CUMBERLAND
CITY COUNCIL

Our Ref: OA2021/0005
DPIE Ref: SSD-10399

Subject: Request for Comments - State Significant Development (SSD)
Application No: SSD-10399
Property: 44 Clunies Ross Street & Great Western Highway, PROSPECT NSW 2145
615A Great Western Highway & Boral House – Clunies Ross Street,
PEMWULWUY NSW 2145
Proposal: Proposed warehouse and logistics estate at Clunies Ross Street,
Pemulwuy

01 SECTION C-C
SCALE 1:100 @ A3

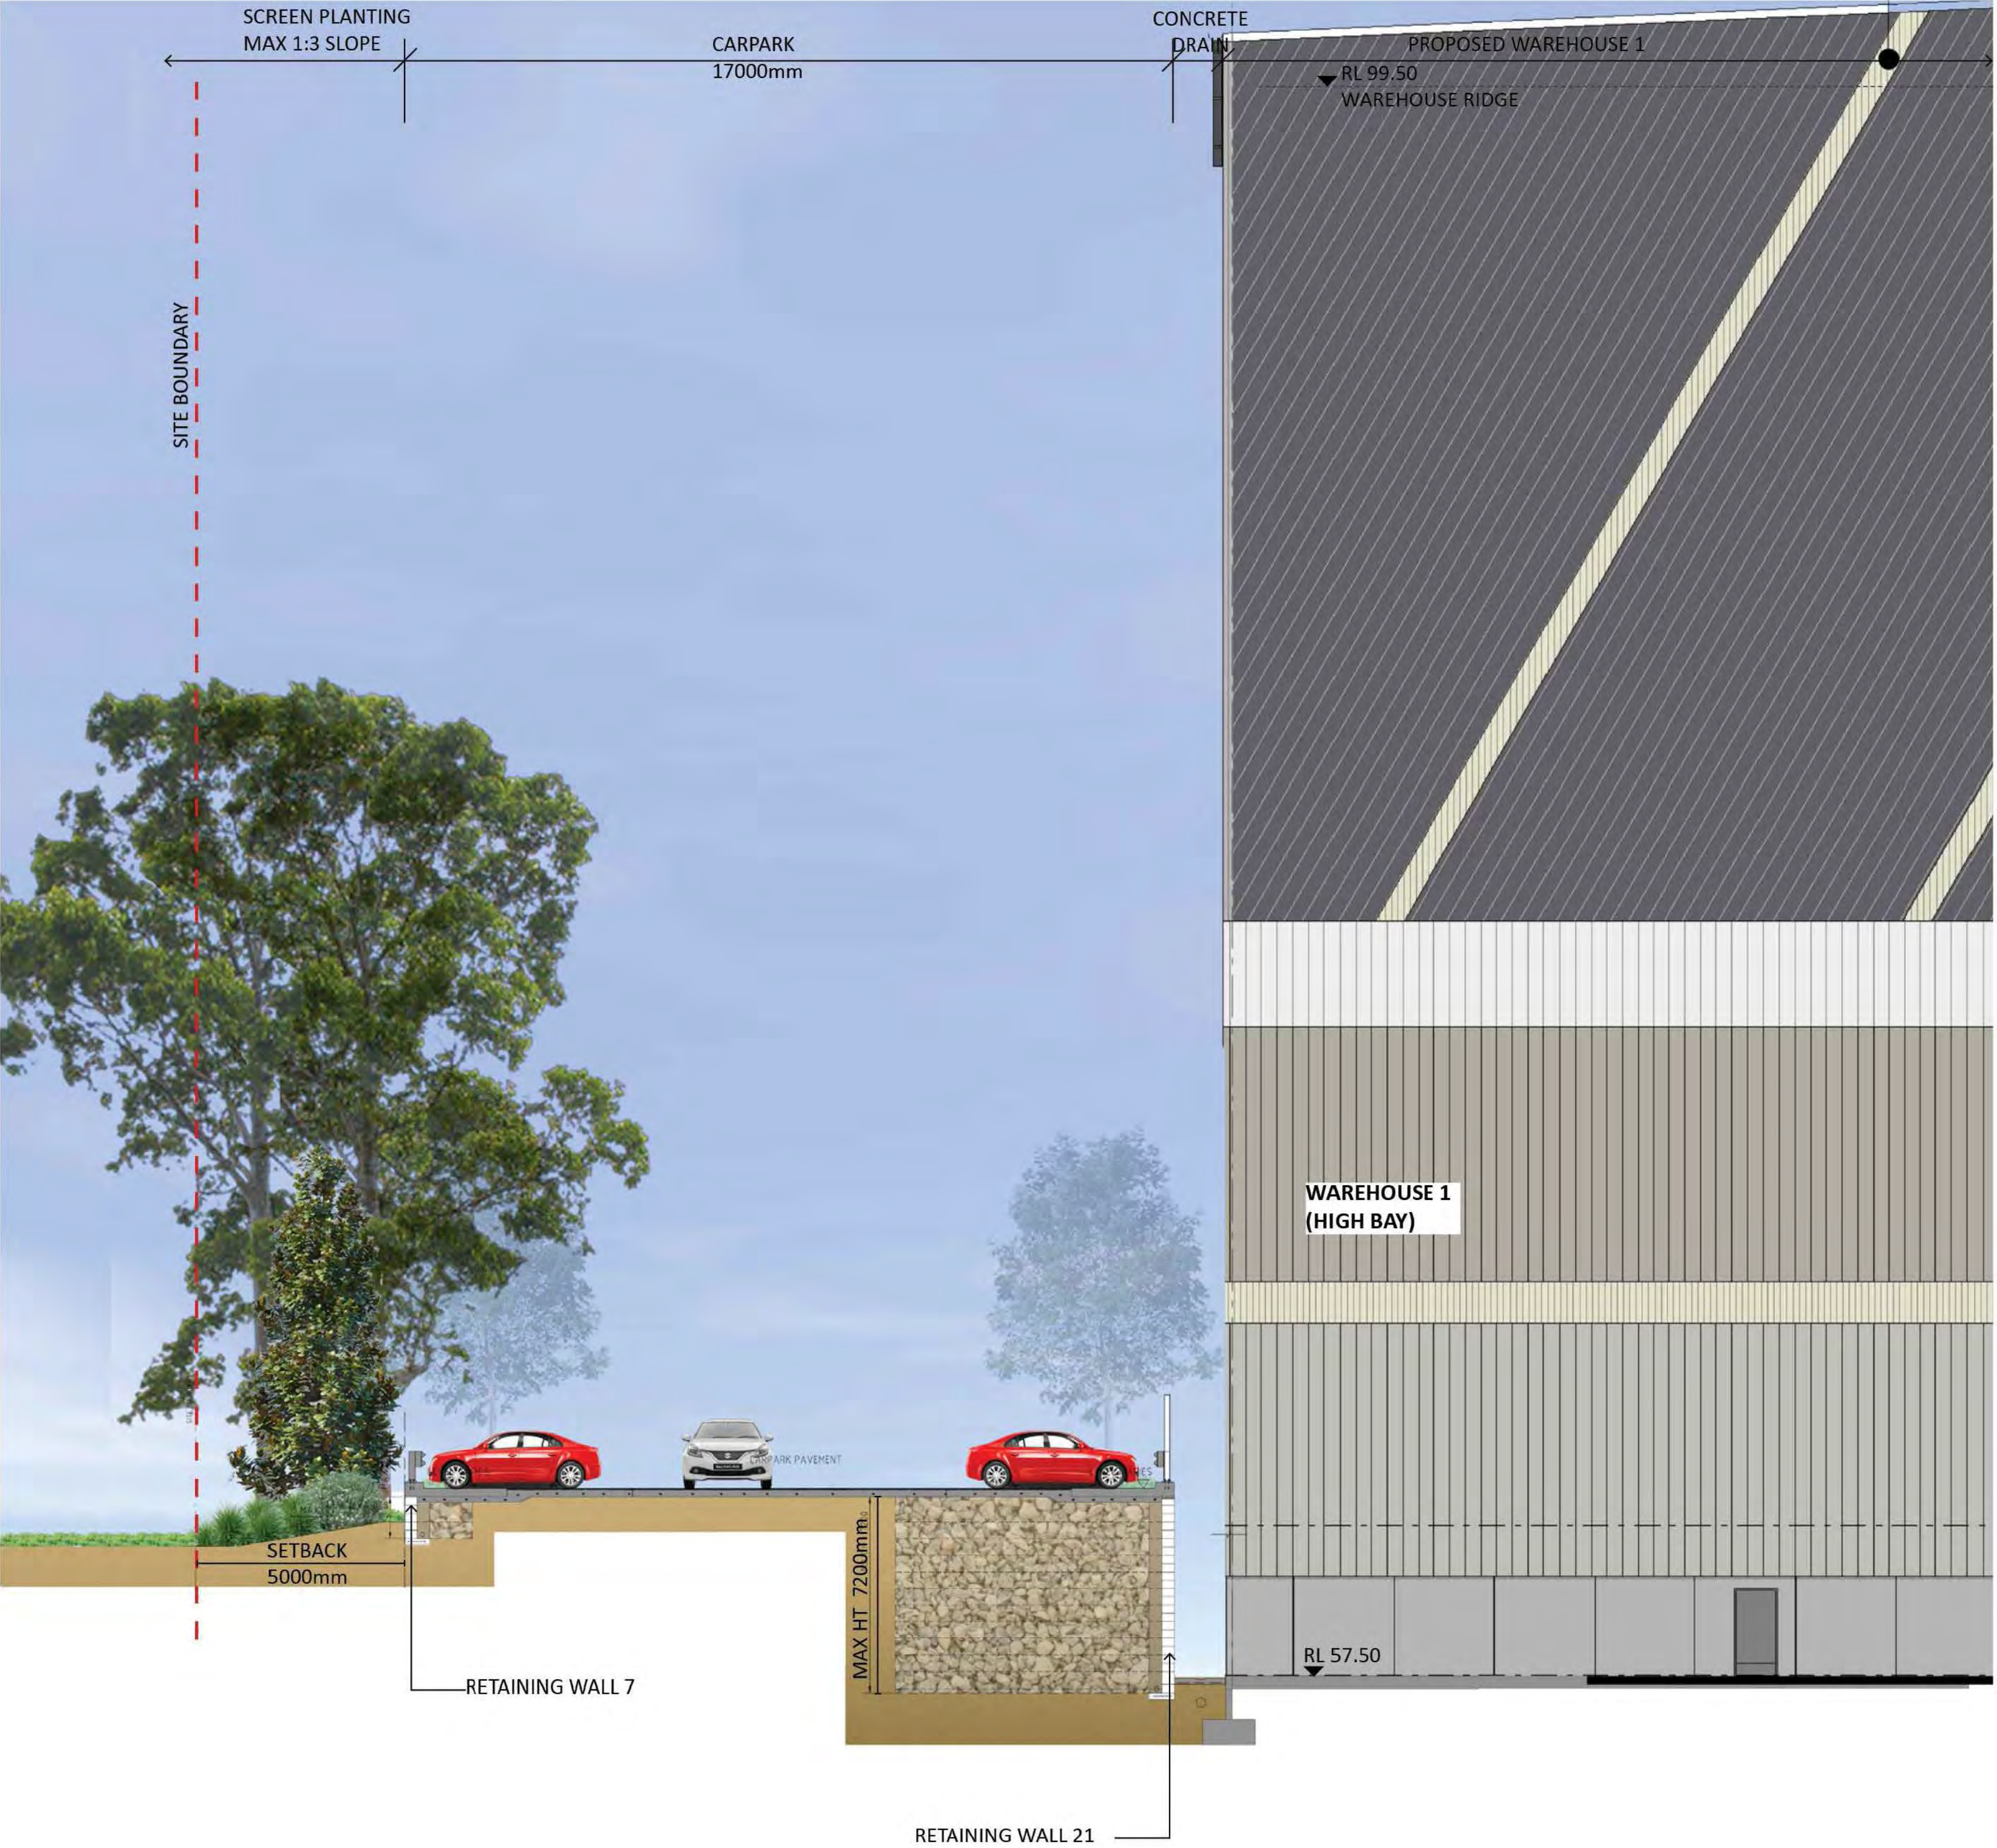
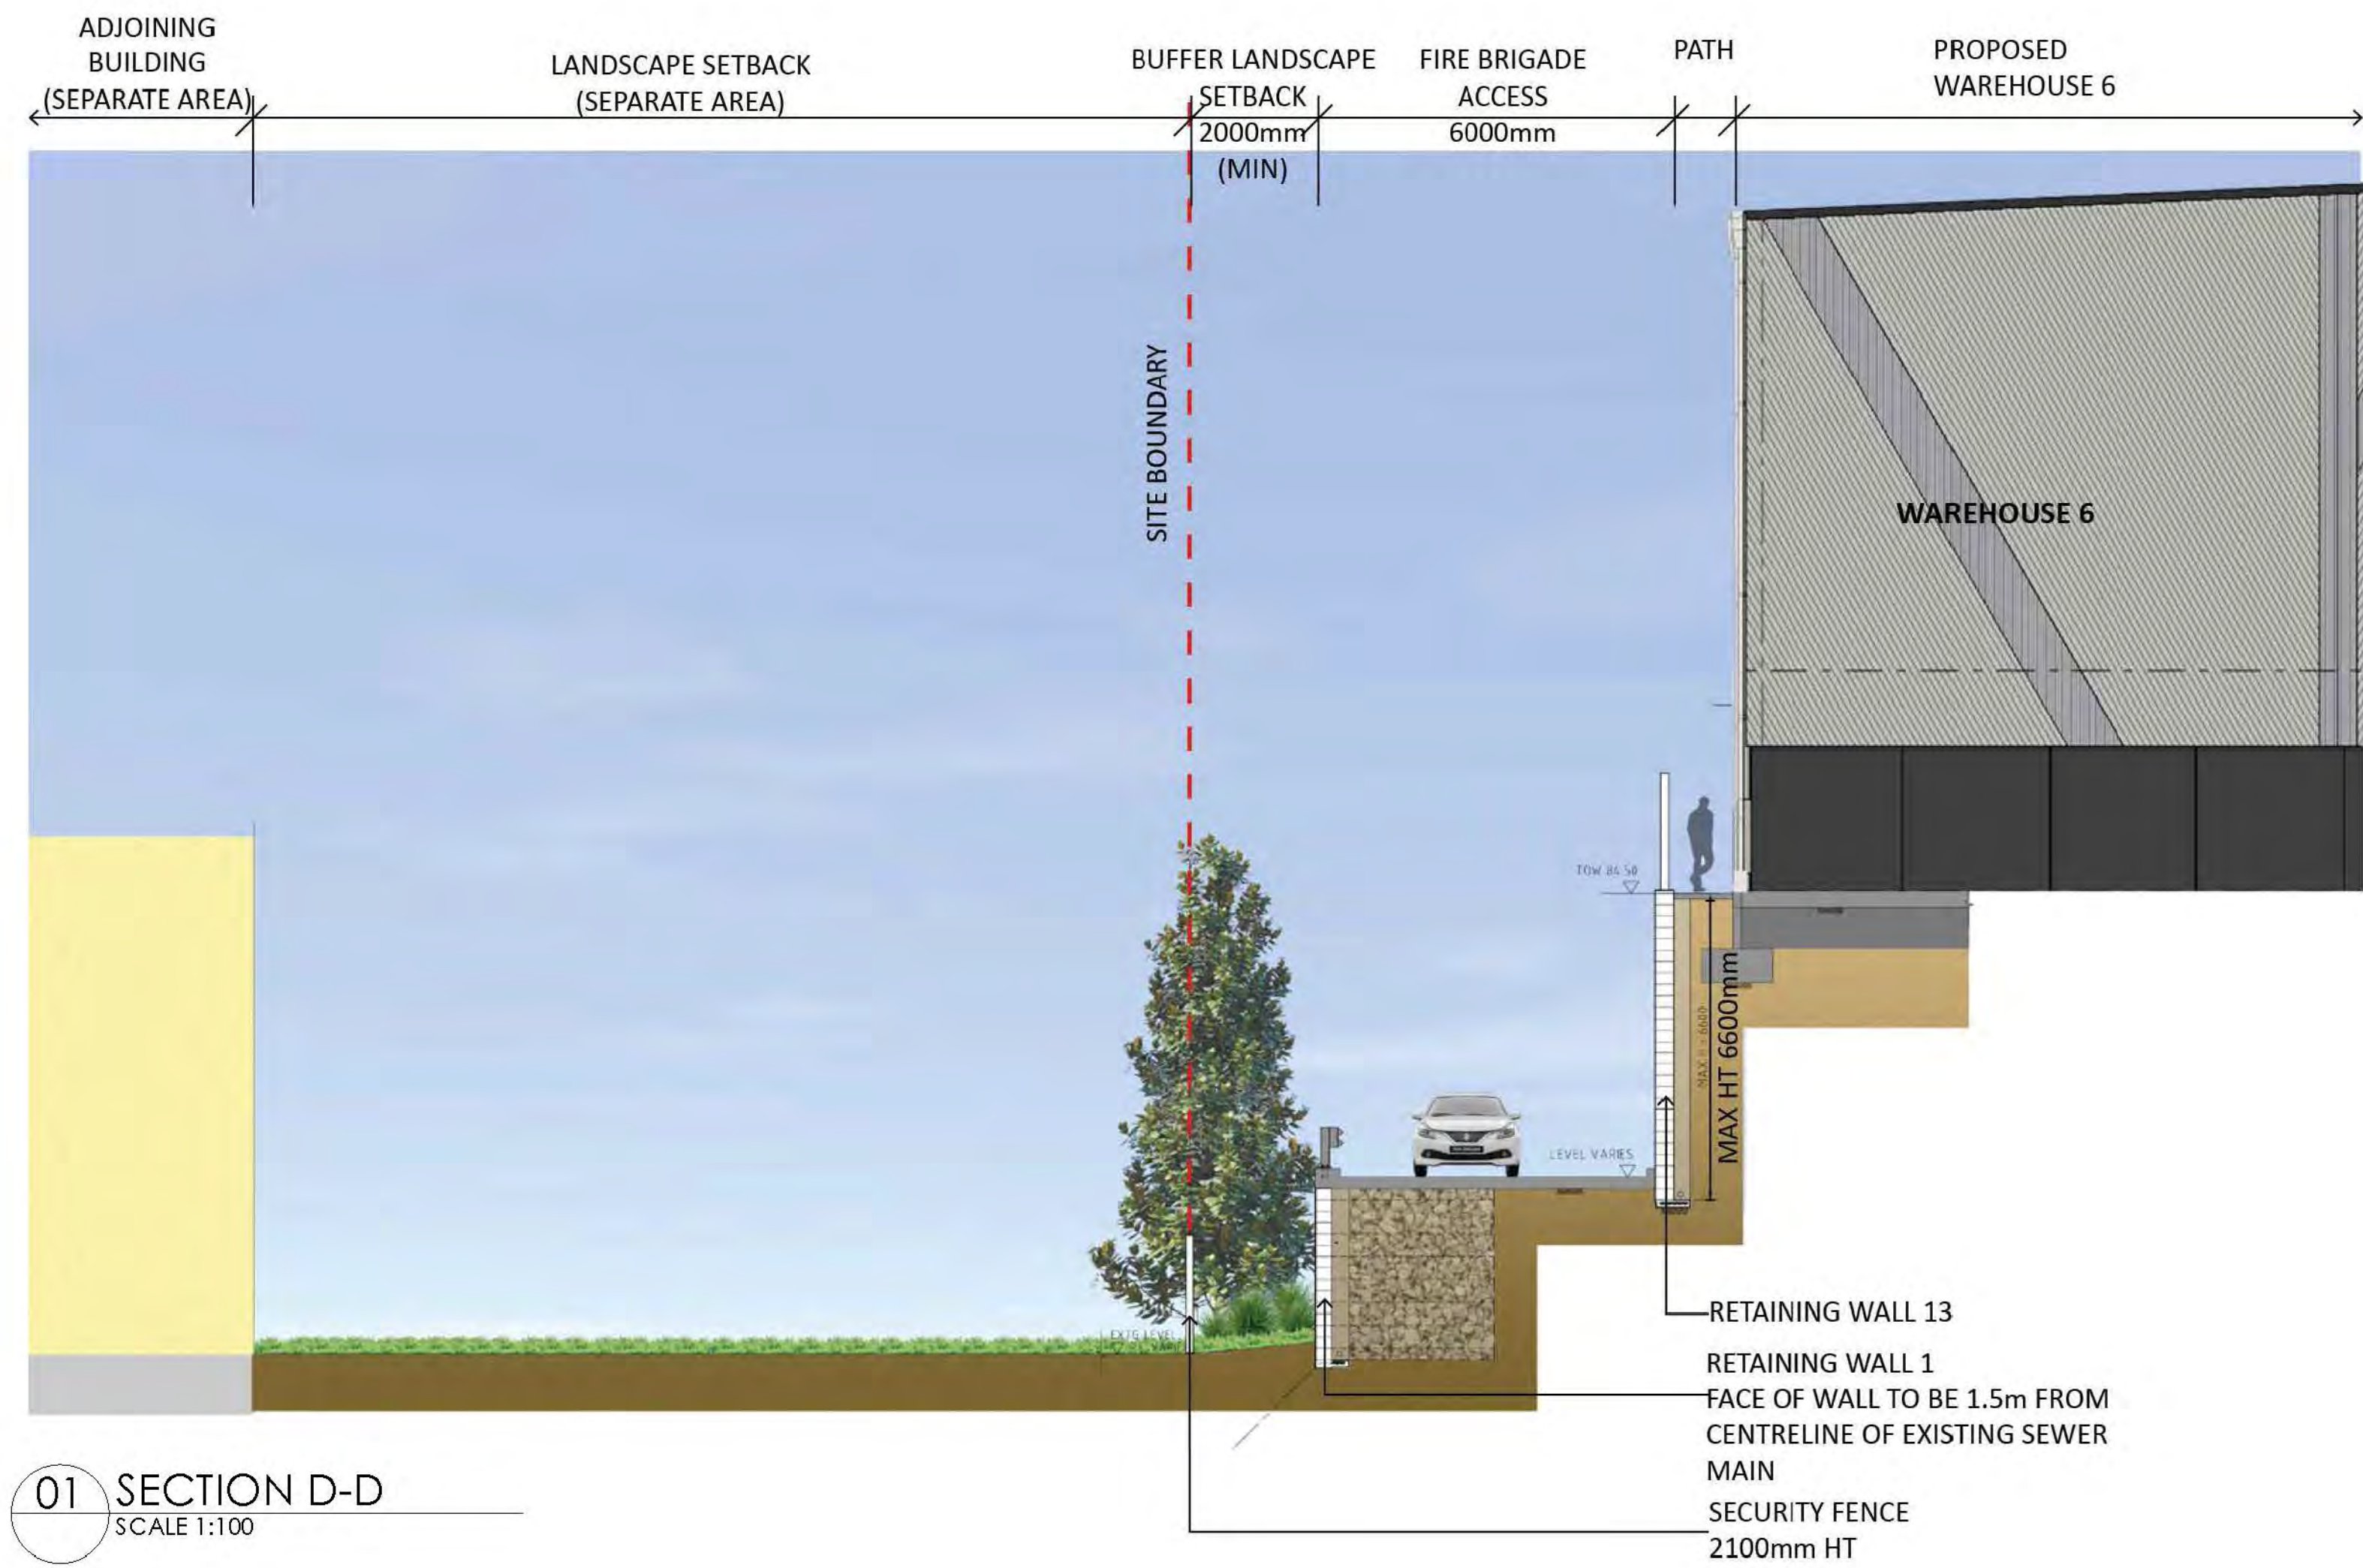
13. Despite of the justification provided in the Statement of Heritage Impact (SoHI), the proposed mature screen planting separating Warehouse 3, 4 and 5 from the view from Prospect Hill is considered to be inadequate as it consists only 1 row of trees along the edge of the heritage reserve and the parking area. The trees proposed will not provide the canopy density to screen such large buildings. Further to that, no plan of the development is included in the SoHI for cross referencing, to show proposed buildings, civil works and, importantly the landscape design and screen planting. Any conditions of consent should mandate recessive tones as well as trees that, at maturity, will screen the development.
